# CITY OF ALBUQUERQUE

August 26, 2025

**Re: Lobo Plaza  
1300 Lomas NE  
Conceptual Traffic Circulation Layout for DFT Approval  
Engineer's Stamp 8-22-25 (J15D028) TRANS-2025-00233**

SITE PLAN - DFT

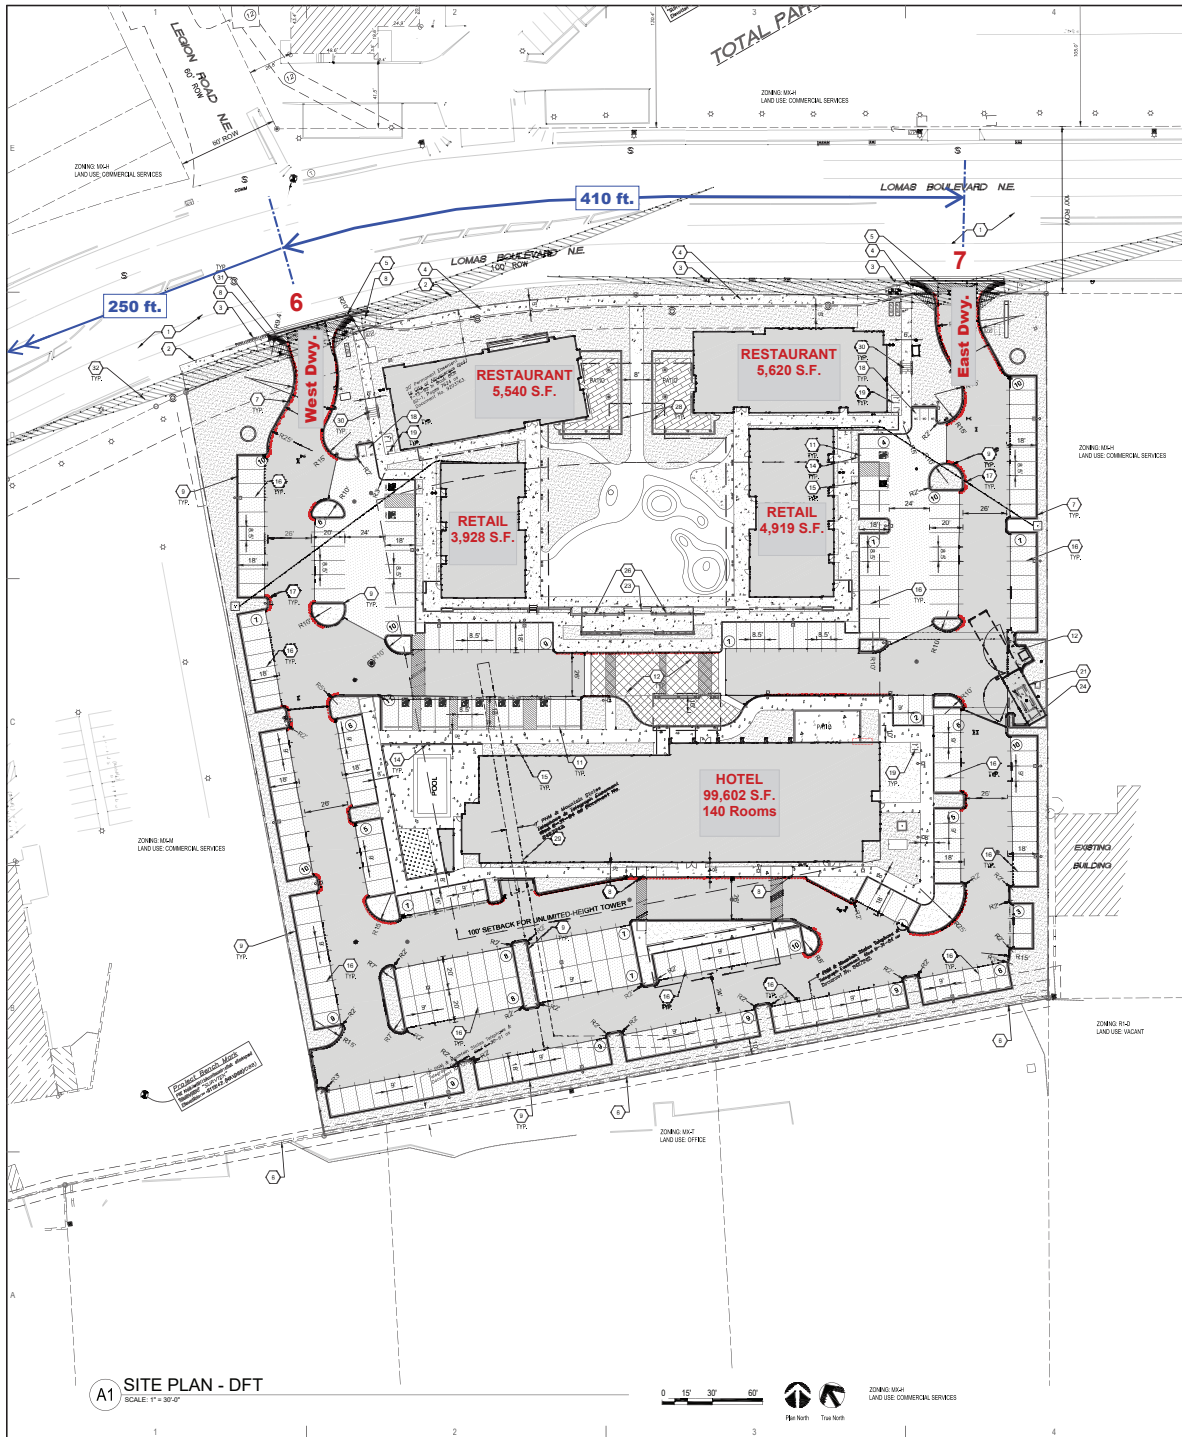
**1-A 6 ft sidewalk, and 5-6 ft Landscape/Buffer along Lomas are required and be shown on the TCL plan**
